Mosman  
COUNCIL

21 October 2011

**Re: Submission on Preferred Project Report and amended plans MP08\_0046**

## **Submission of Mosman Council regarding d'Albora Marina MP08 0046 following review of the Preferred Project Report and amended plans**

DMS:DA03 (Issue 1) / A15 Only GR

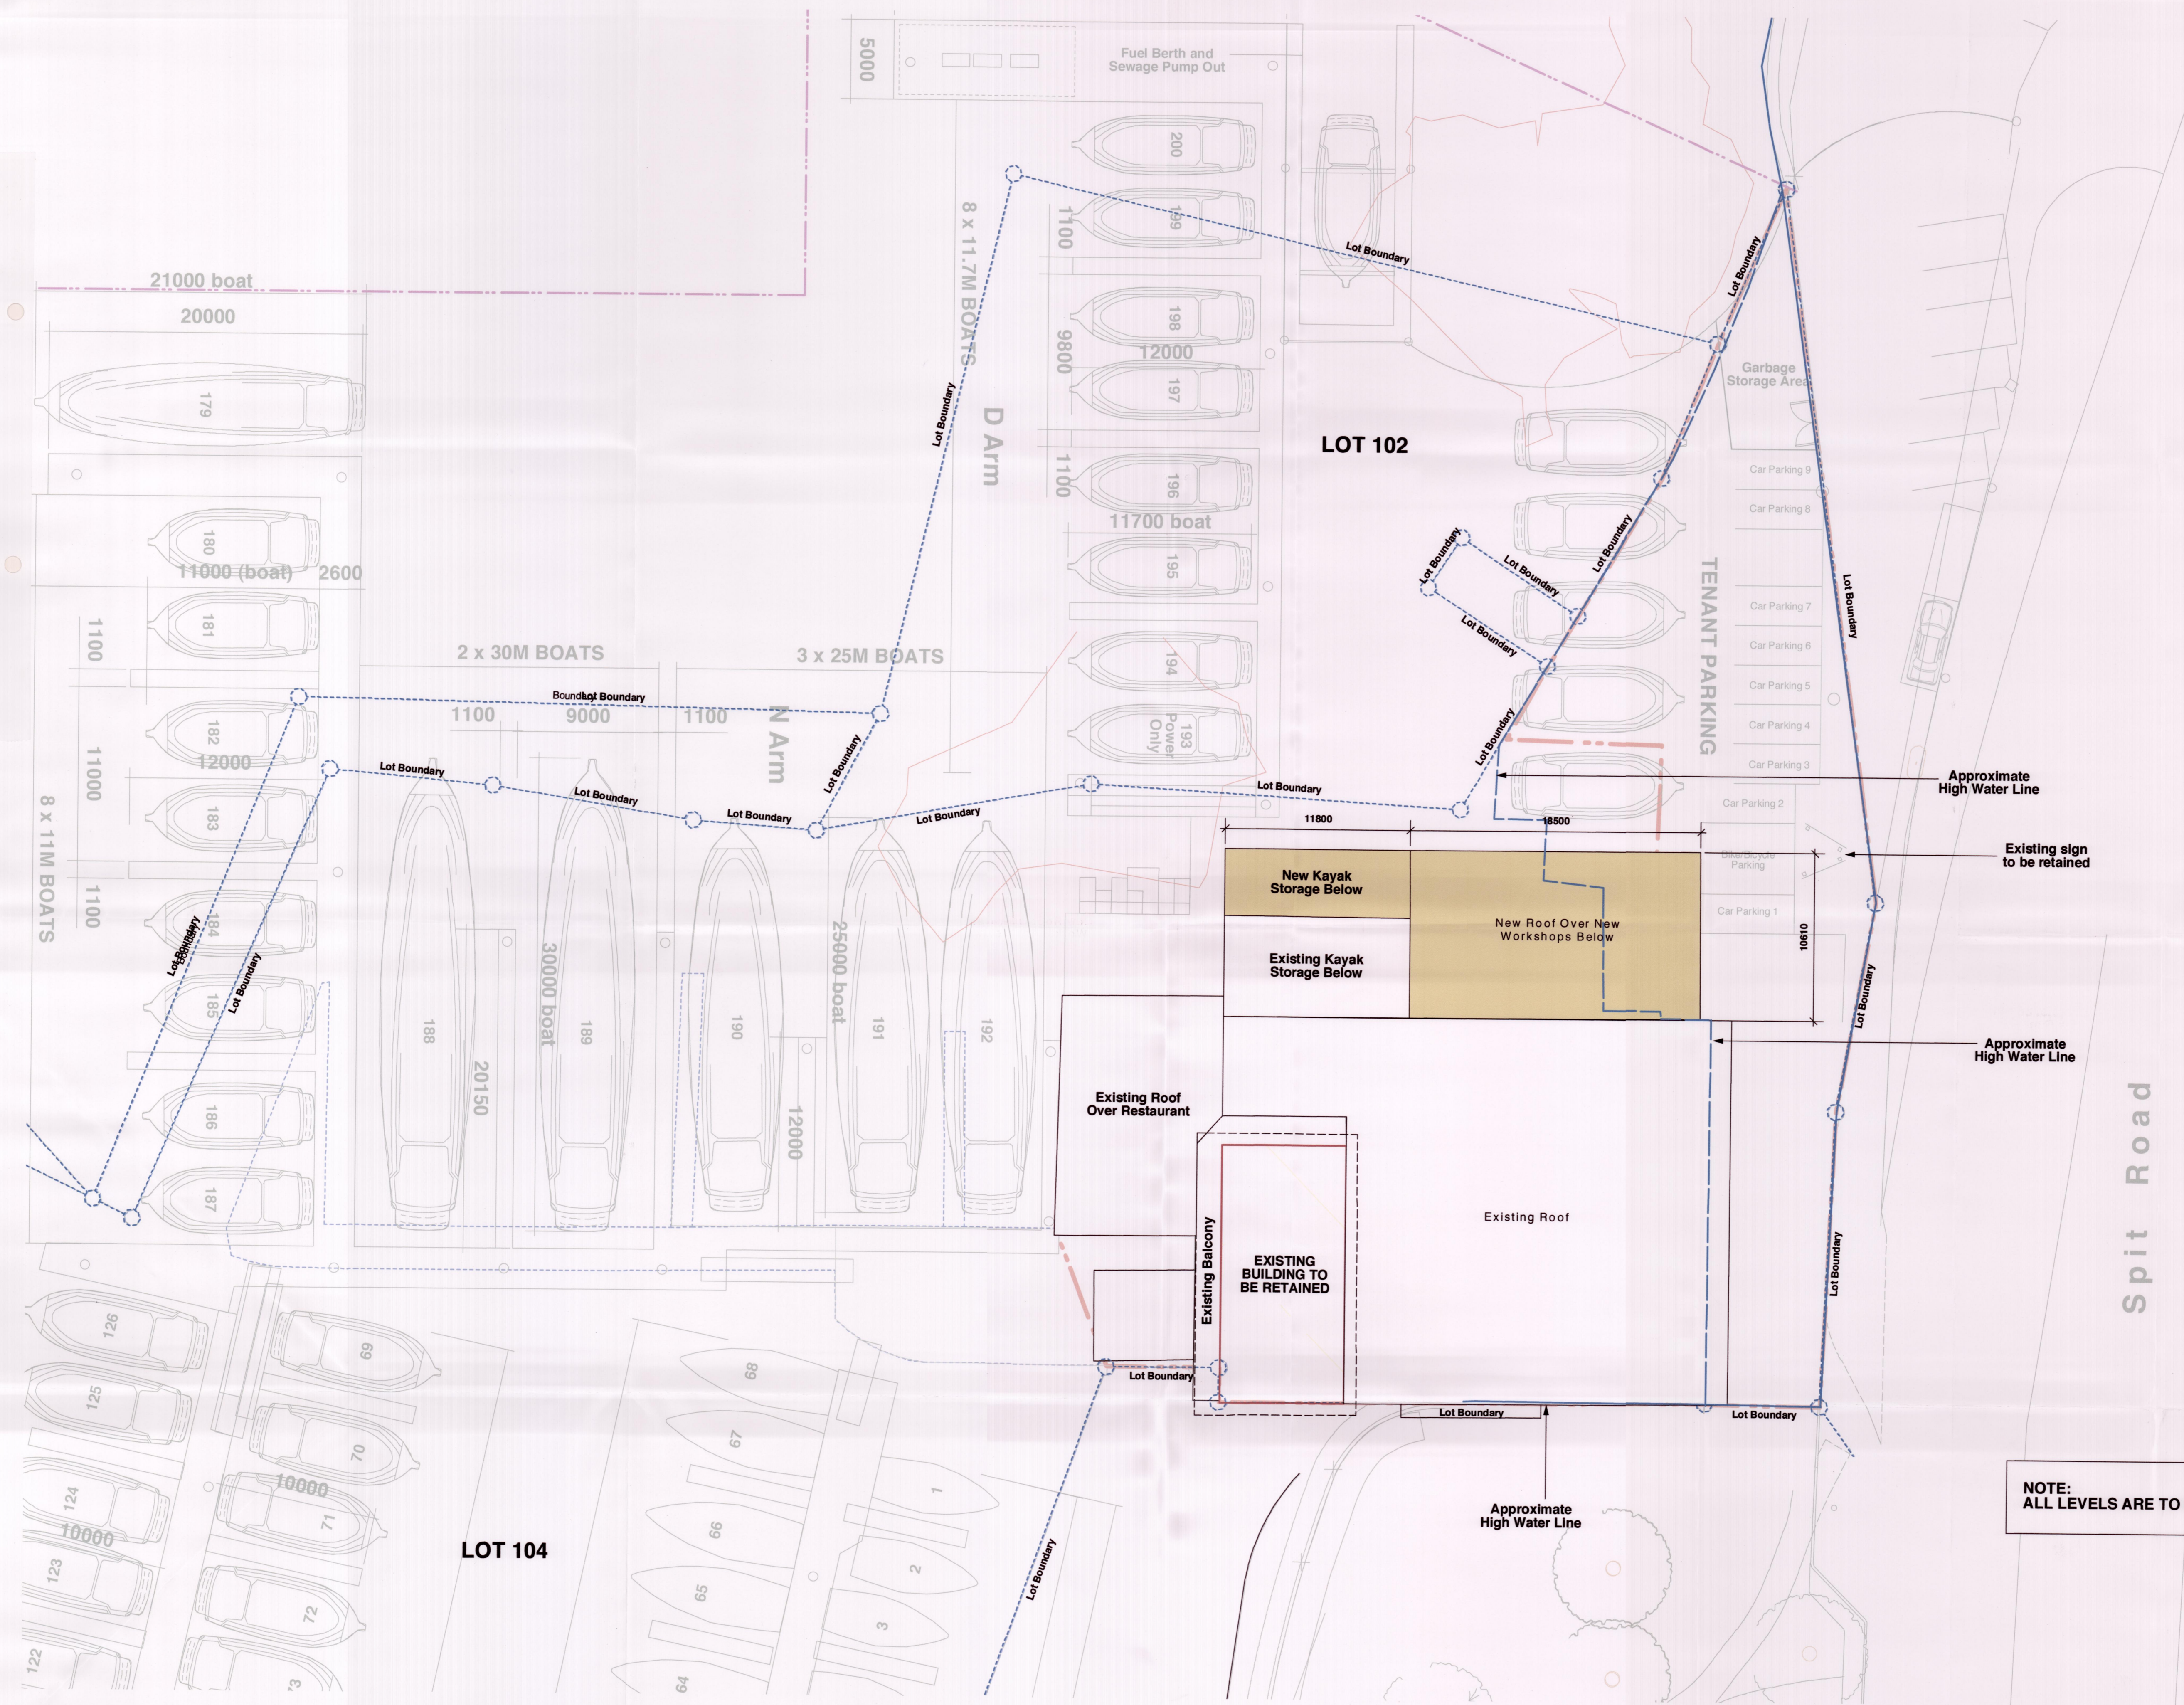
The amended plans do not contain sufficient detail in relation to the indented manoeuvring bay and what the impact on other road users will be when a truck is parked or manoeuvring in this location. It is noted the RTA raised similar issues in its submission. For example, it is not clear how other vehicles will access the Ellery Park carpark and the proposed carparking area; how north and south-bound cyclists using the regional bike route over Spit Bridge and pedestrians will safely move through the area; and how traffic will be managed if trucks are required to queue.

From what can be seen from the application plans both pedestrians and cyclists would need to cross the enlarged entry apron to proceed to Spit West pathways or under the bridge to Spit East. As presented this would not be appropriate or adequate and should be resolved as a precondition of any new building work on the site. Council's study provides an opportunity in this respect.

The relationship of the moored boats, particularly in the extended Arm A may also be a matter of concern due to the limited manoeuvring space between the seawall and the marina. The plans still do not identify the new sea wall and viewing platform which is regularly used for fishing and even with the current configuration has led to conflicts, including claims of fishermen casting lures on to passing vessels, etc.
